Planning Act 2008 – Section 88 and the Infrastructure Planning (Examination Procedure) Rules 2010 – Deadline 6: Deferral of Environment Agency response to Deadline 7

Application by NNB Generation Company (SZC) Limited for an Order Granting Development Consent for the Sizewell C Project

Sizewell Link Road Flood Risk Assessment Addendum [REP5-045]

Plate 7.8. Maximum water levels for crossing SW3 for the 1 in 100-year +35%CC - long-section

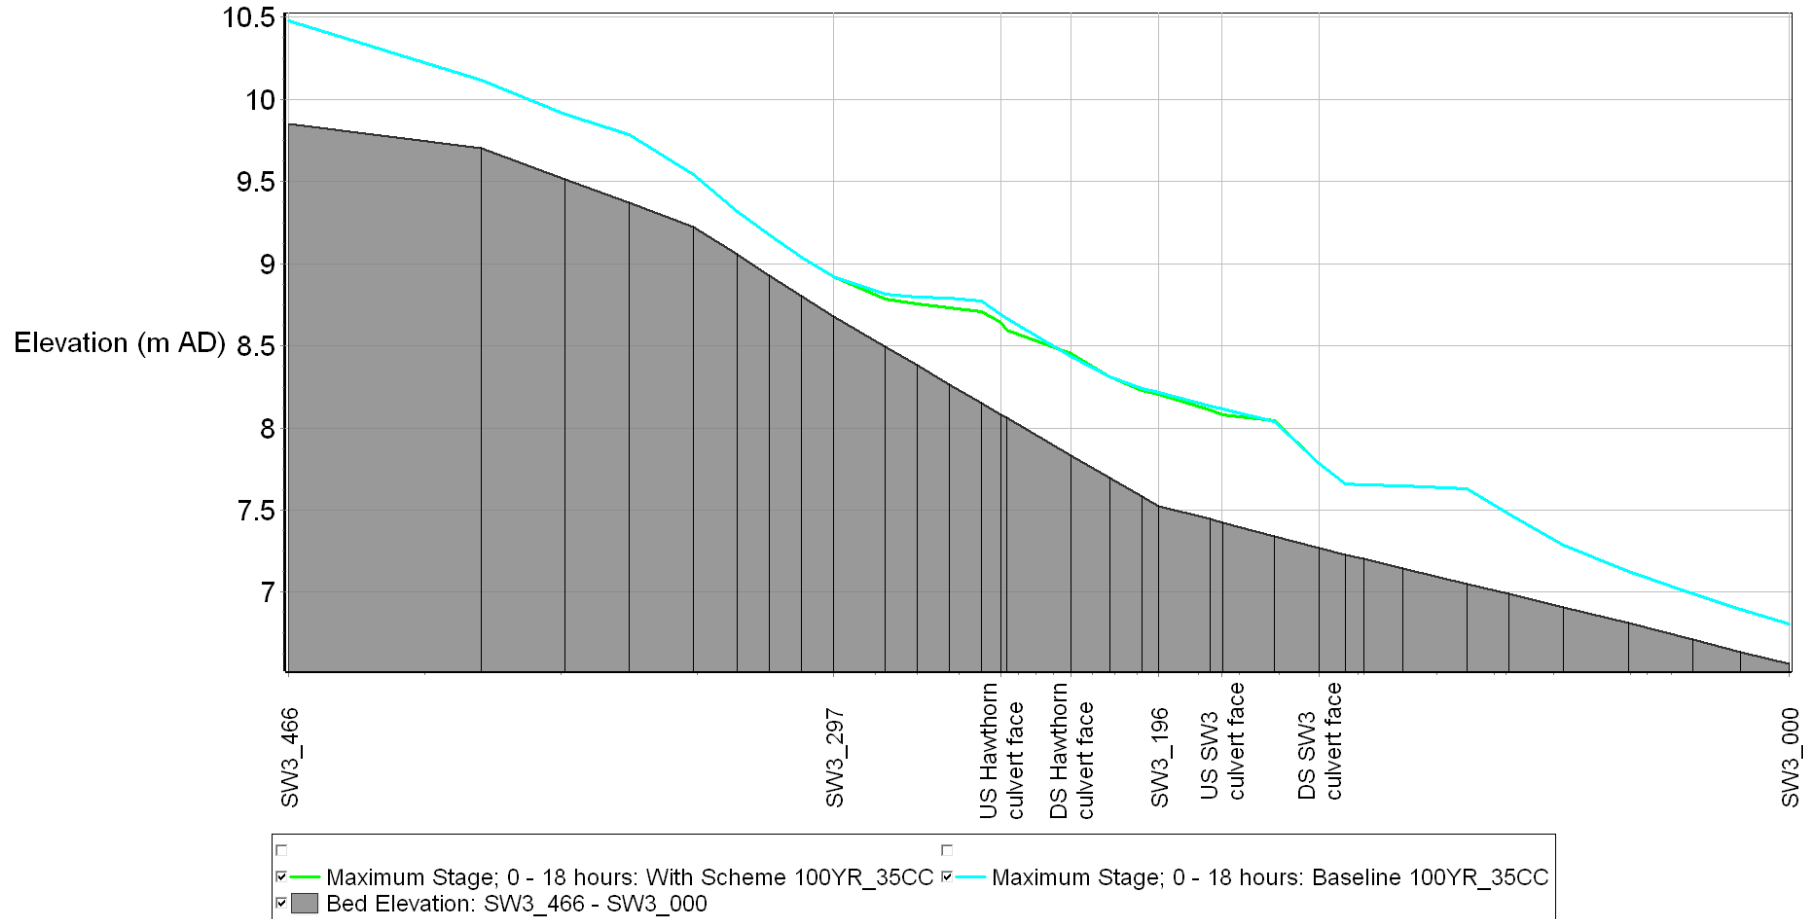
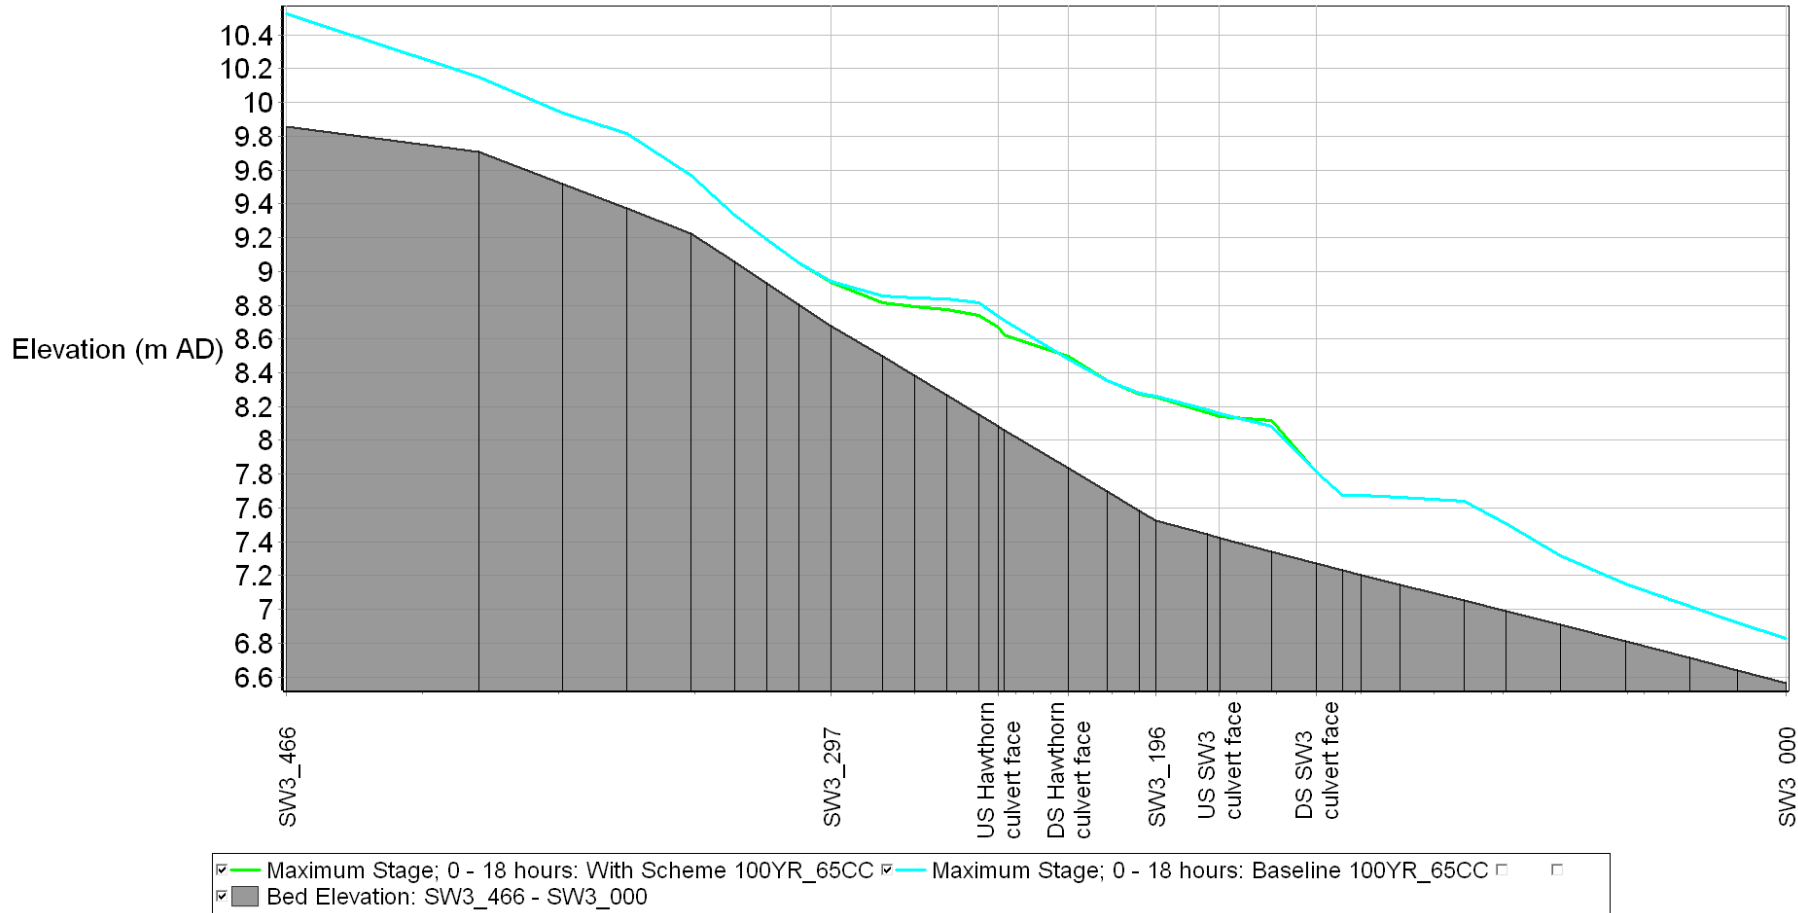
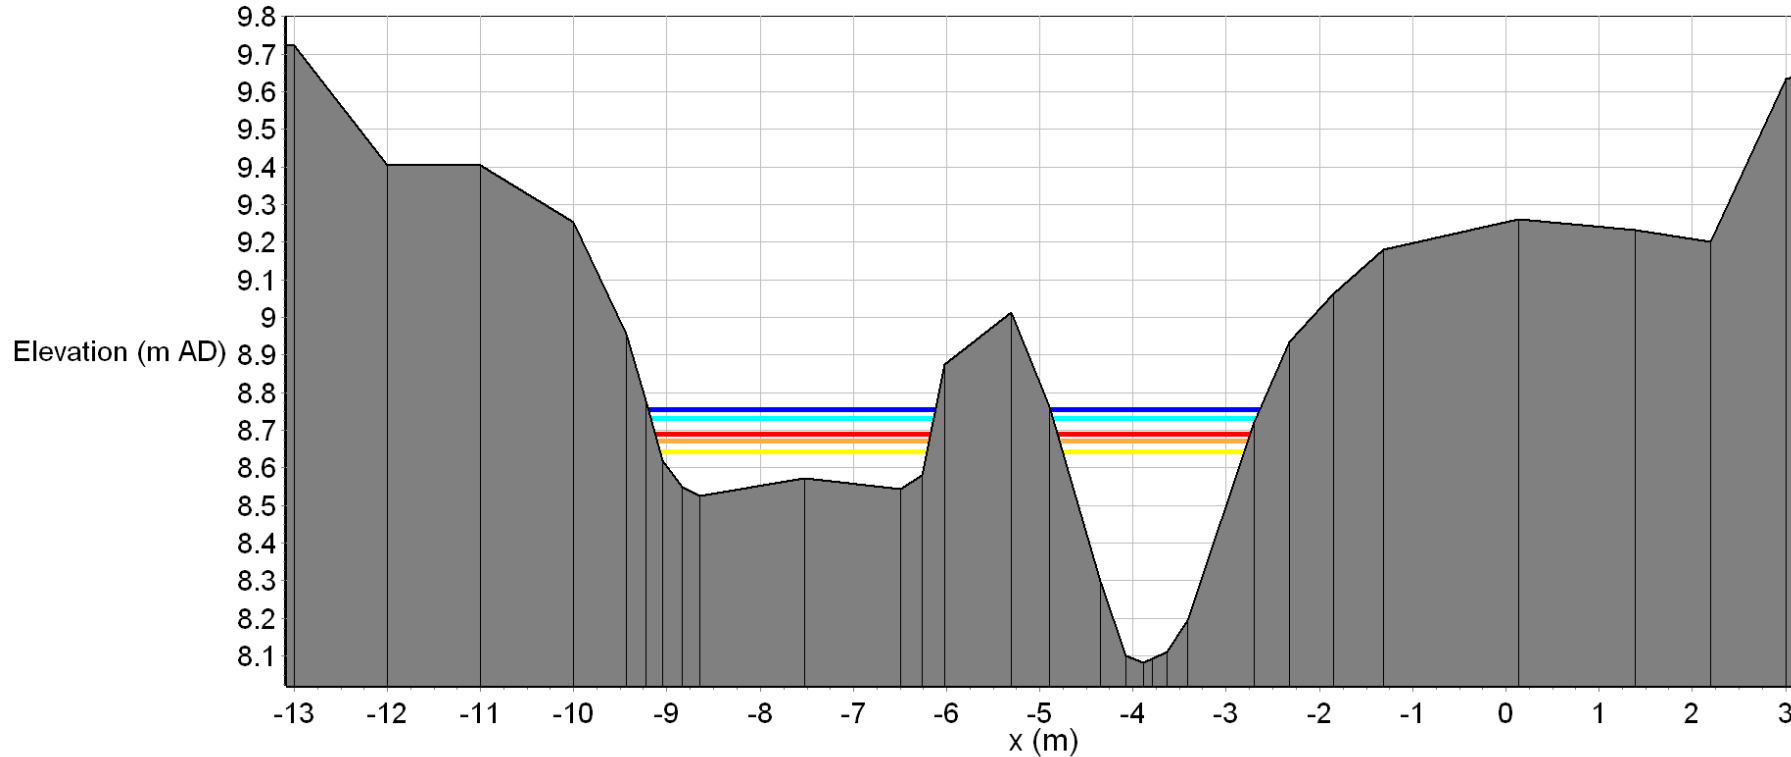
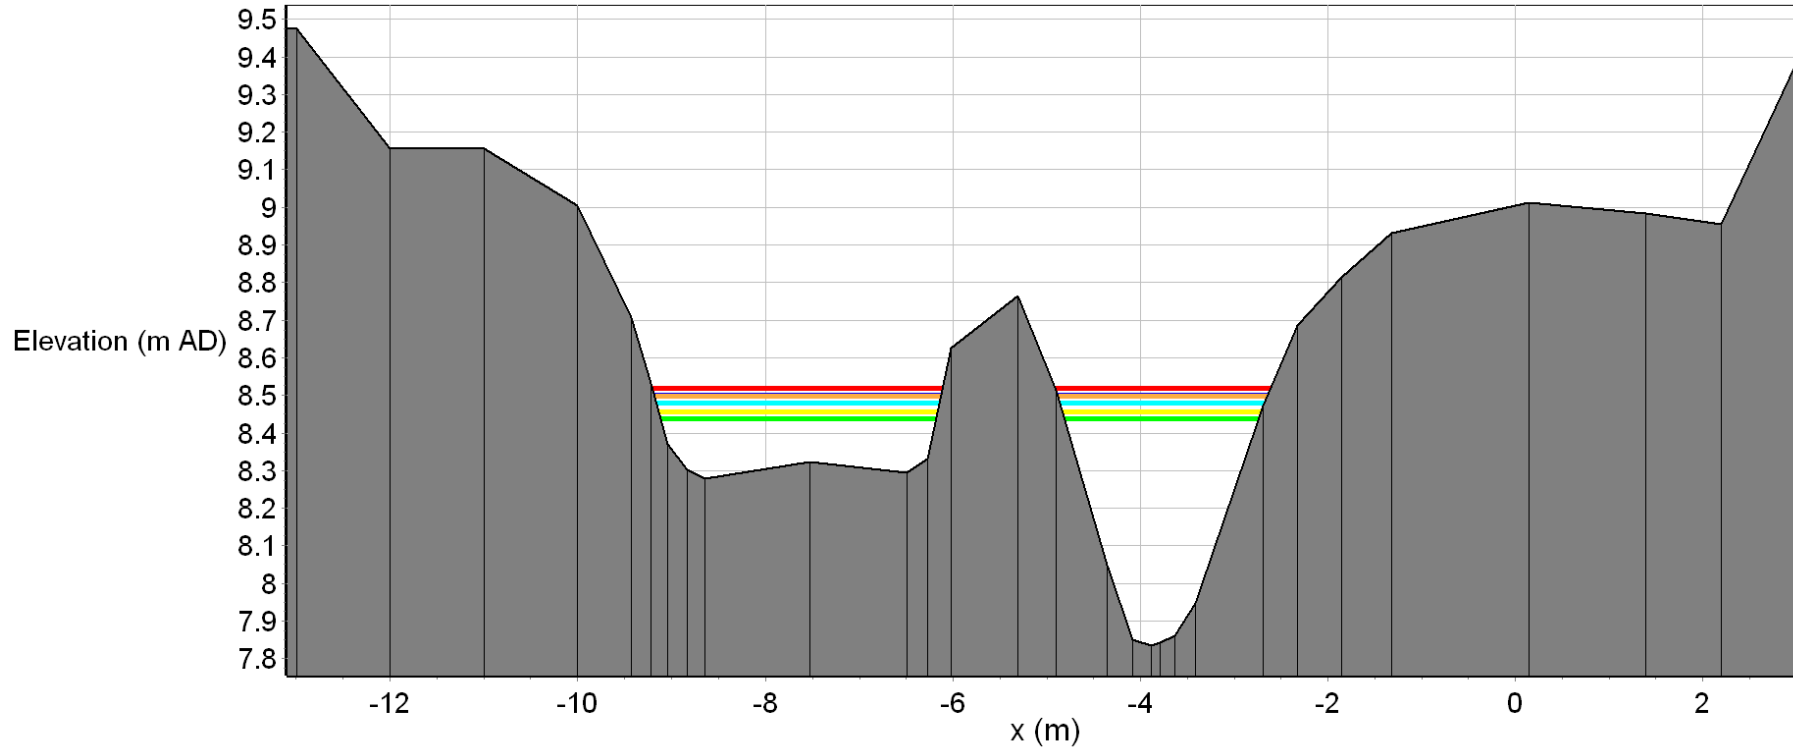
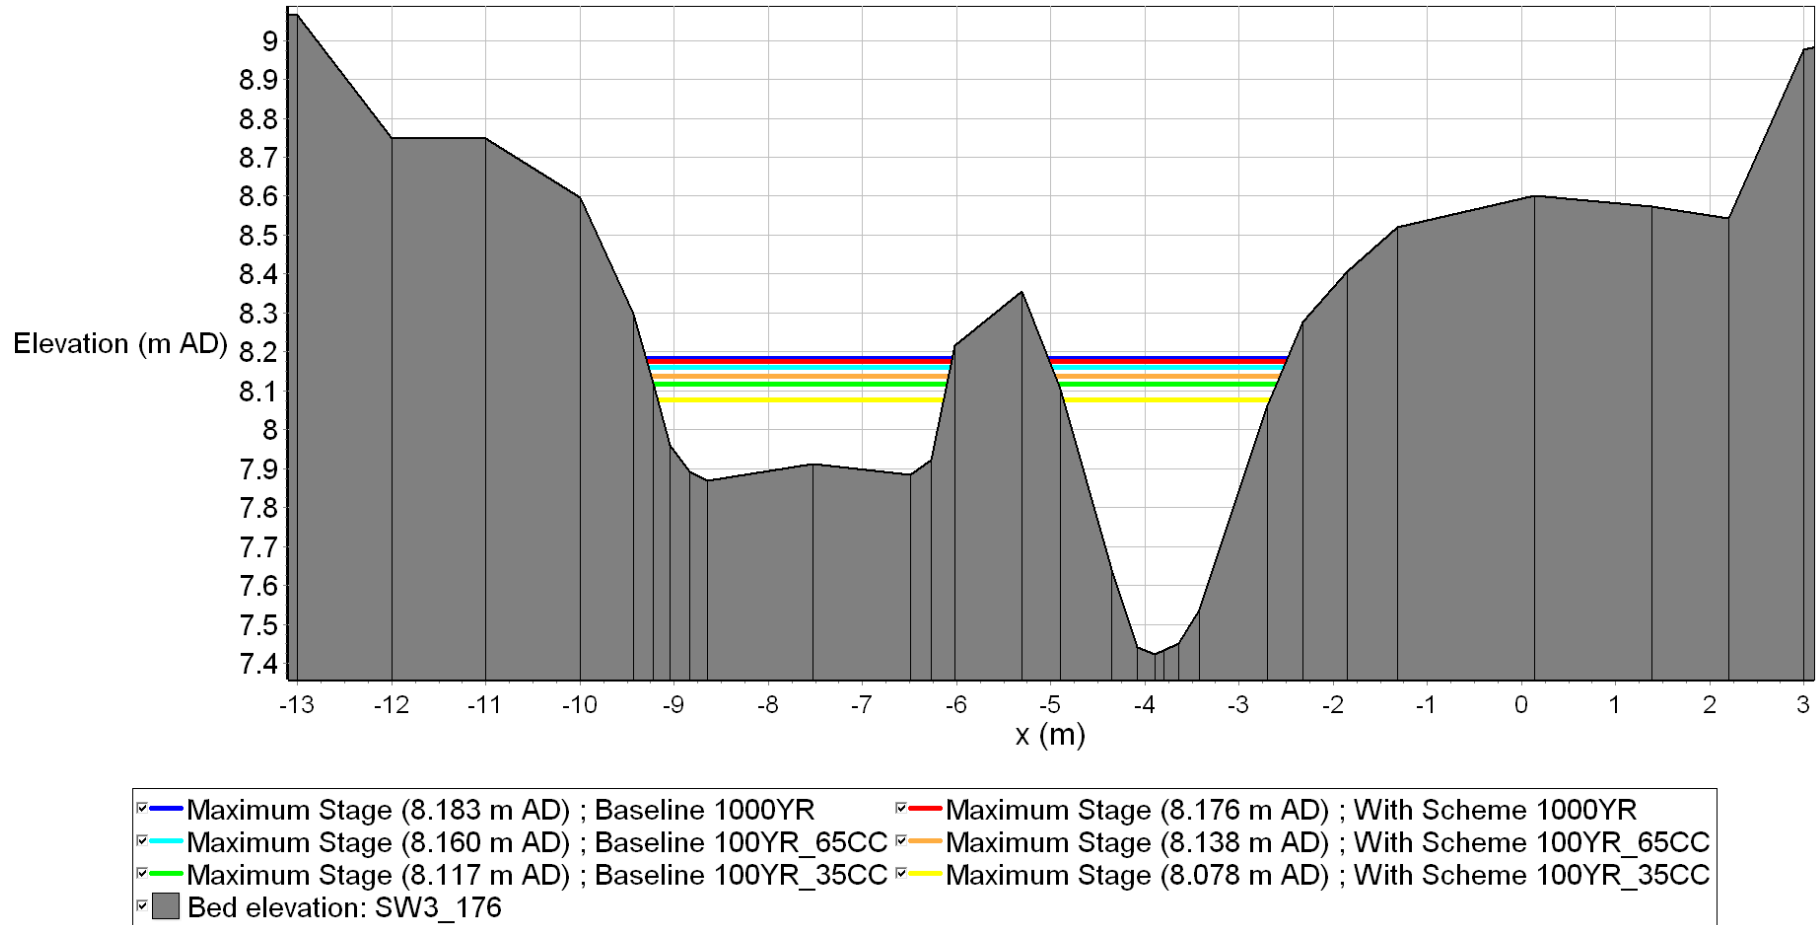
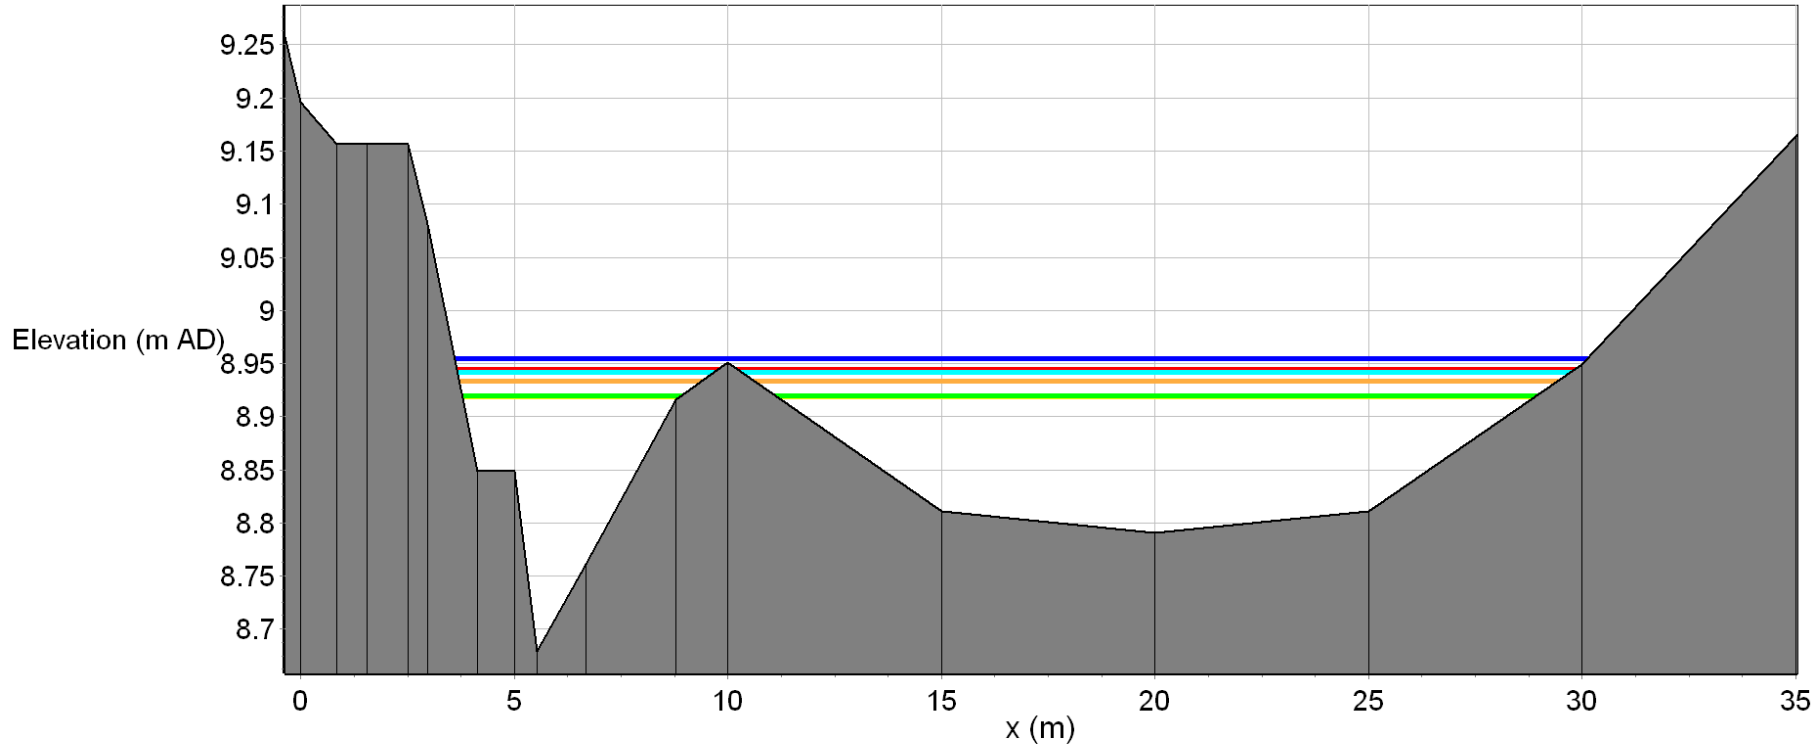
- There remains an increase in flood risk at crossings SW1 and SW3, and the applicant has clarified that this is entirely within the site boundary. We do not consider the increase in flood risk to be significant at these locations.
